Subject: RE: al/62/20/pl

Amber Willard
Planning Officer

I am the officer [REDACTED] Village Academy.

ORMISTON SIX VILLAGES ACADEMY

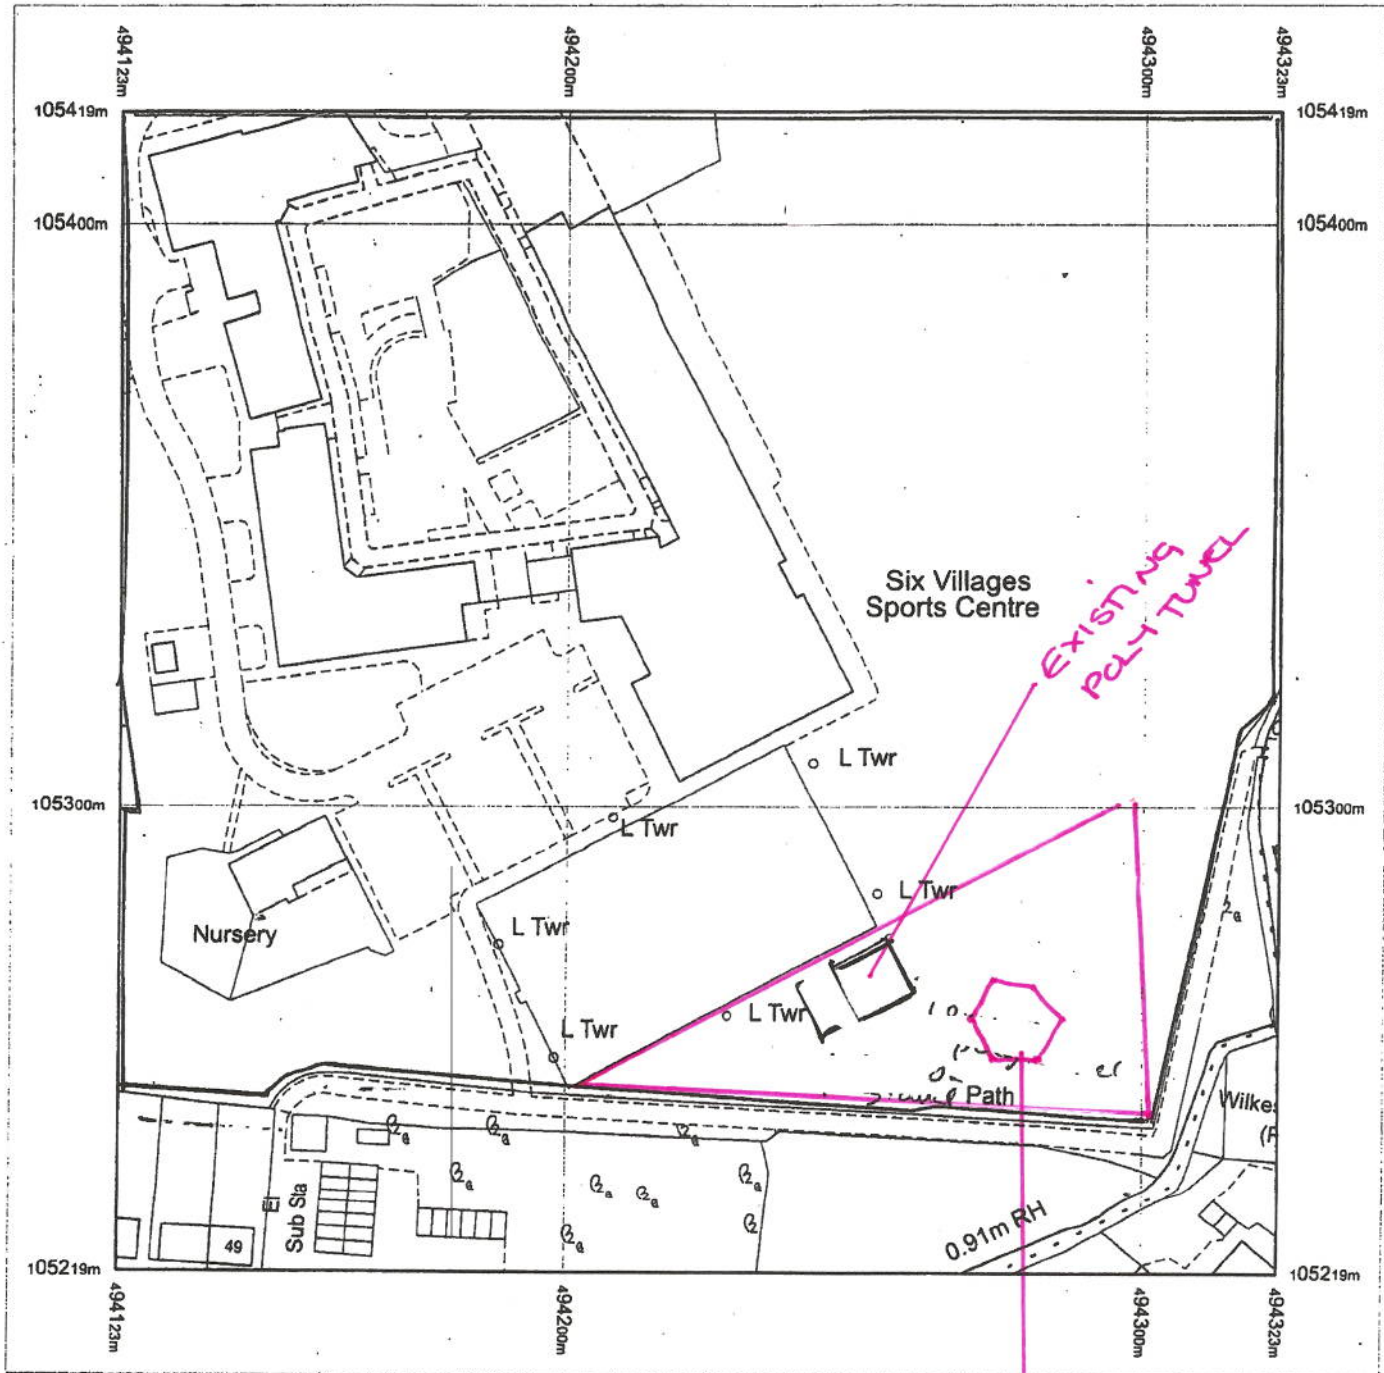
However are you able to mark on where the lodge would go as from the current block plan submitted (below) it would appear outside this yellow edged area.

1. A plan showing the development's relationship with the existing playing pitches on this part of the site. The proposed timber lodge appears to be sited on part of the playing field that has been marked out for formal playing pitches in recent years. However it is not possible from the drawings and information submitted to identify what the impact of the structure would be on those playing pitches and whether, if they are affected, that the pitches together with adequate safety run off areas can be satisfactorily re-provided. '

Yes I can see that error now. I have highlighted on the attached. Apologies It isn't an octagon in my drawing!

I have attached a plan of the site. It is highlighted in yellow. Google maps shows it overgrown but it has been cleared. This clearly shows where the sports pitches are in relation to the site. This area is now fenced off completely and will be used for educational purposes. This area has always been an educational area.
